**From:** Contact Centre (CRM) <contact@ribblevalley.gov.uk>  
**Sent:** 16 February 2022 20:31  
**To:** Planning  
**Subject:** Planning Application Comments - 3/2021/0789

**Planning Application Reference No.:** 3/2021/0789

**Address of Development:** 46 Eshton Terrace, Clitheroe, BB7 1BQ

Replacement window and new door access to Laundrette

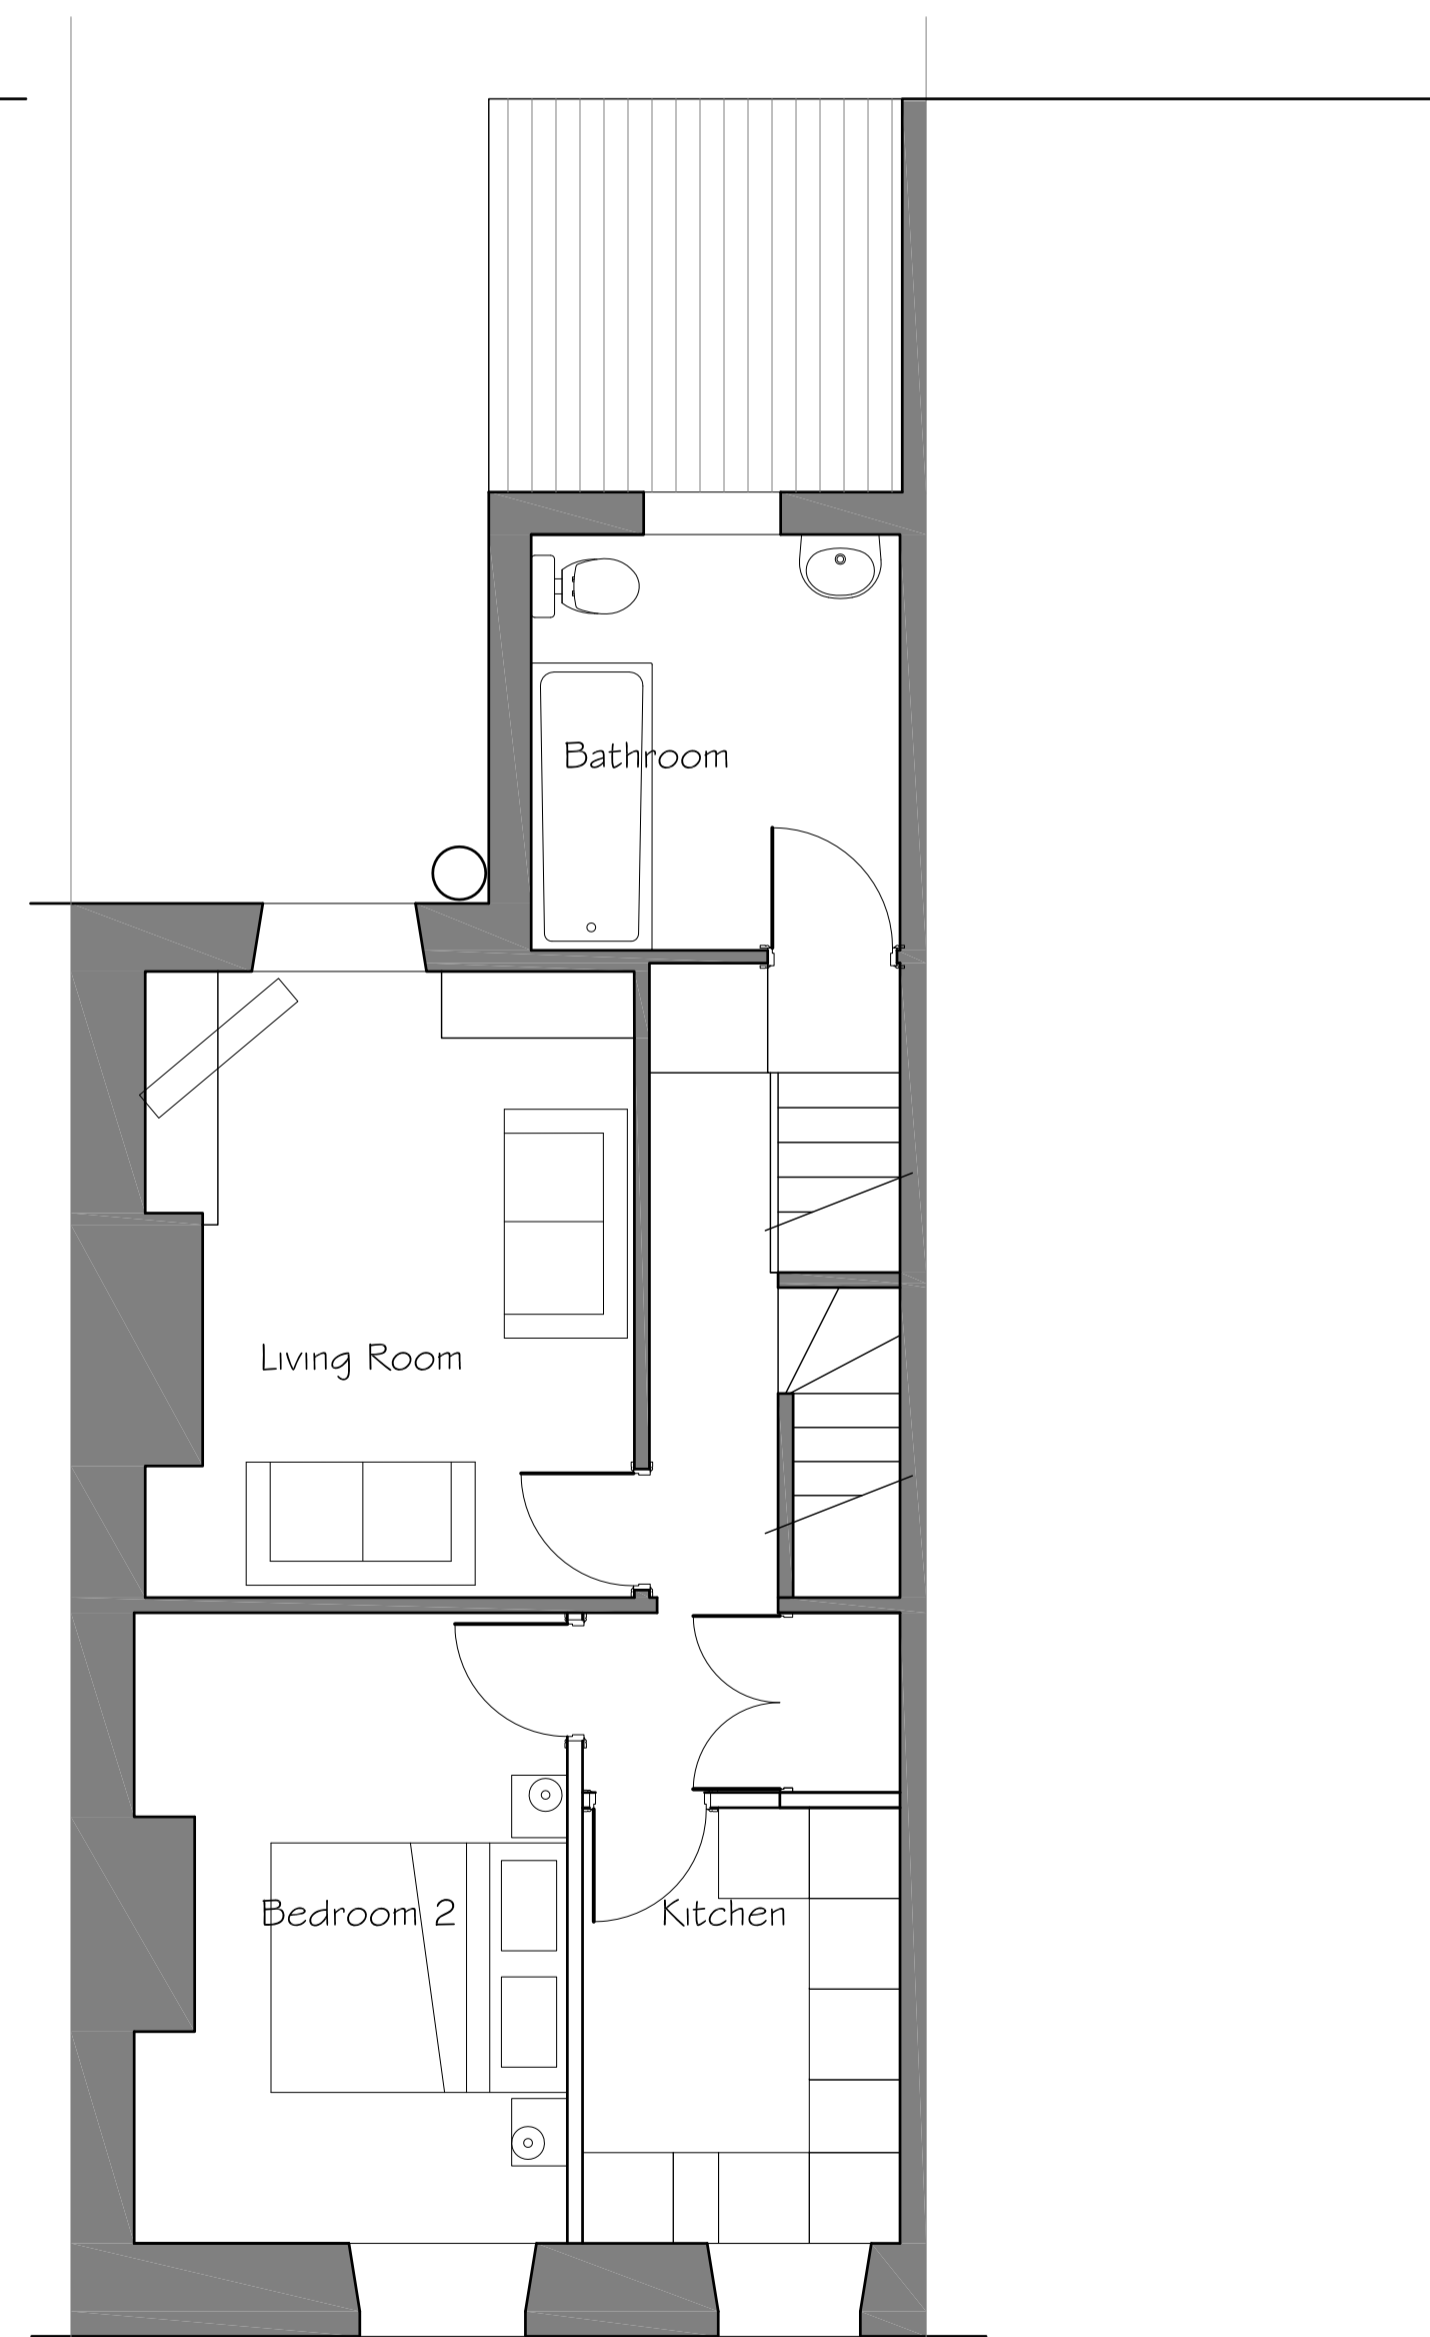
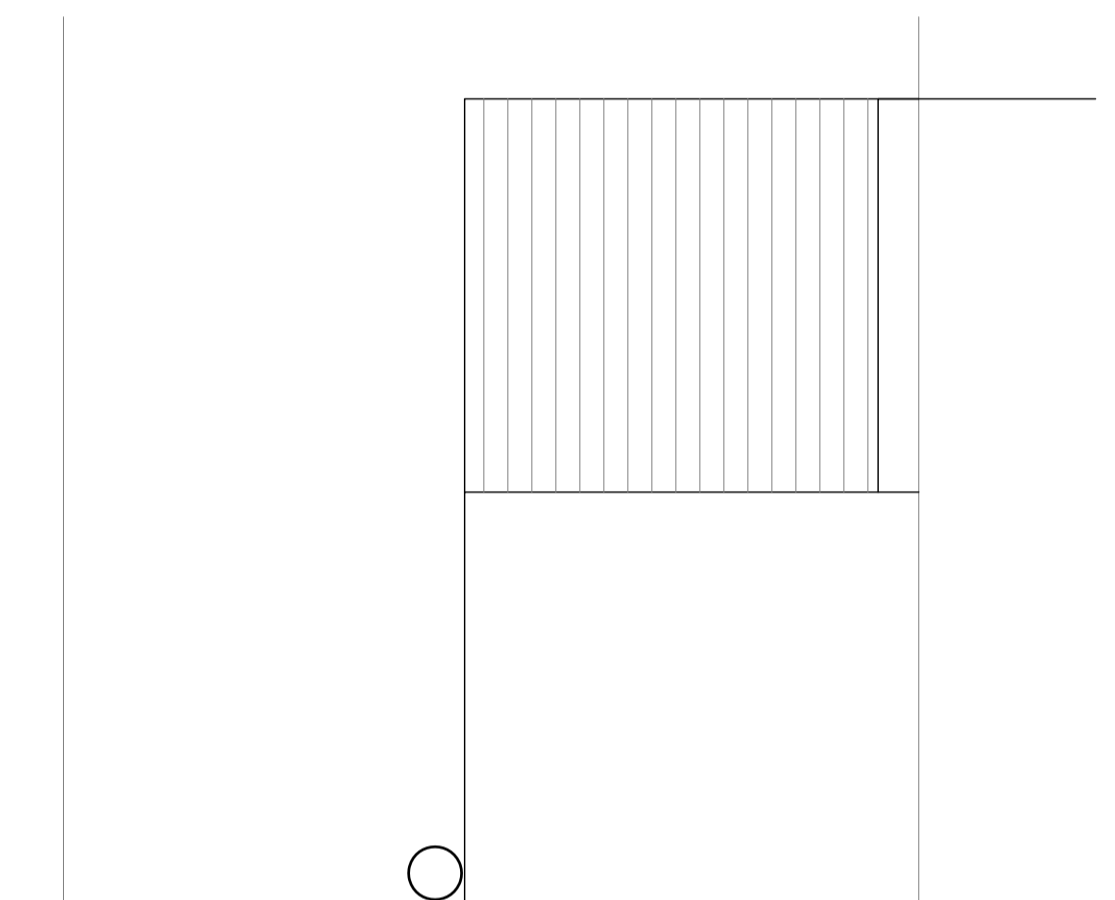
**Comments:** Further to the notice of Amended Information Received: I understand that the amendments are shown on an amended proposed plan which now show (1) a conservation style rooflight and dormer window rather than x2 dormer windows (2) a door to the left side of the existing window rather than extending the window to close to ground level with a central door. Unfortunately these changes diminish the historical pattern of door and windows to a greater extent than the original proposed plans. In the case of (1) the windows in the rear facing roof - the twin dormers at least would be recognisable as being for the same property whereas mixing the types of rear roof windows will confuse the remaining appearance of the whole. Two dormers would match the property at [REDACTED]. Two rooflights would offer minimal disruption and might therefore be superior but aren't proposed. Two different forms offers the most disruption to the remaining historical appearance of the rear roof of this section of terrace. In the case of (2) the amended additional front door arrangement the impact is similar - the original proposal was clearly distinct from the existing pattern of front doors and garden paths and was both modern and visually attractive positively balanced against the impact to the existing rhythm of door ways. As there is no additional information added to the design statement I cannot understand the thinking behind the re-design of a doorway to the left of a window - presumably the existing window. The result on the plan looks irregular and jarringly discordant and creates the appearance of a door stuck into a building without any regard to the existing form of the terrace or its appearance. I believe both of these amendments proposed detract from remaining history in the appearance of this section of terrace. Please consider these comments in addition to my previous comments on this application.
